RE: Thoennes Short Plat SP-09-00014

TO: Jeff Watson, Community Development Services  
FROM: Christina Wollman, Planner II *CW*  
DATE: August 20, 2009  
SUBJECT: Thoennes Short Plat SP-09-00014

THOENNESS SHORT PLAT SP
WITHIN A PORTION OF THE NW 1/4 OF THE SW 1/4
SECTION 15 T16N R20EWM, KITTITAS COUNTY, WA

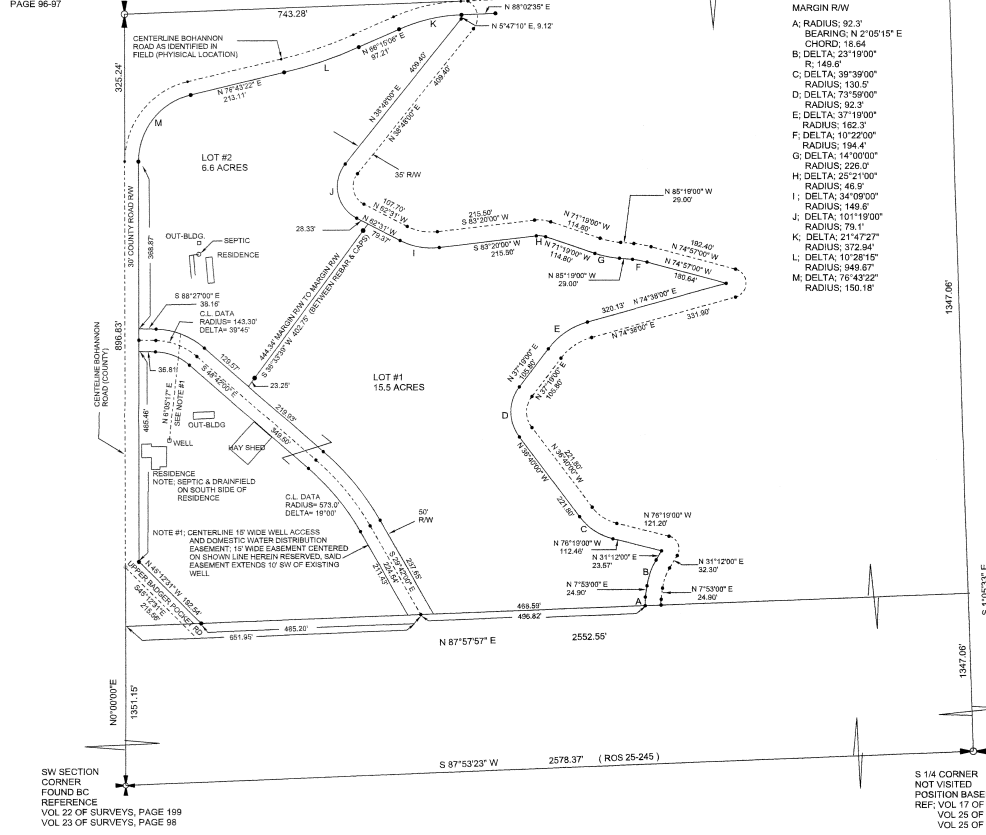
1. Access: Access shall be from the existing driveways.
2. Plat Notes: Plat notes shall reflect the following:
  - a. Maintenance of the access is the responsibility of the property owners who benefit from its use.

- b. An approved access permit will be required from the Department of Public Works prior to creating any new driveway access or performing work within the county road right of way.

- c. Any further subdivision or lots to be served by proposed access may result in further access requirements. See Kittitas County Road Standards.
  - d. A public utility easement 10 feet in width is reserved along all lot lines. The 10 foot easement shall abut the exterior plat boundary and shall be divided 5 feet on each side of interior lot lines. Said easement shall also be used for irrigation.
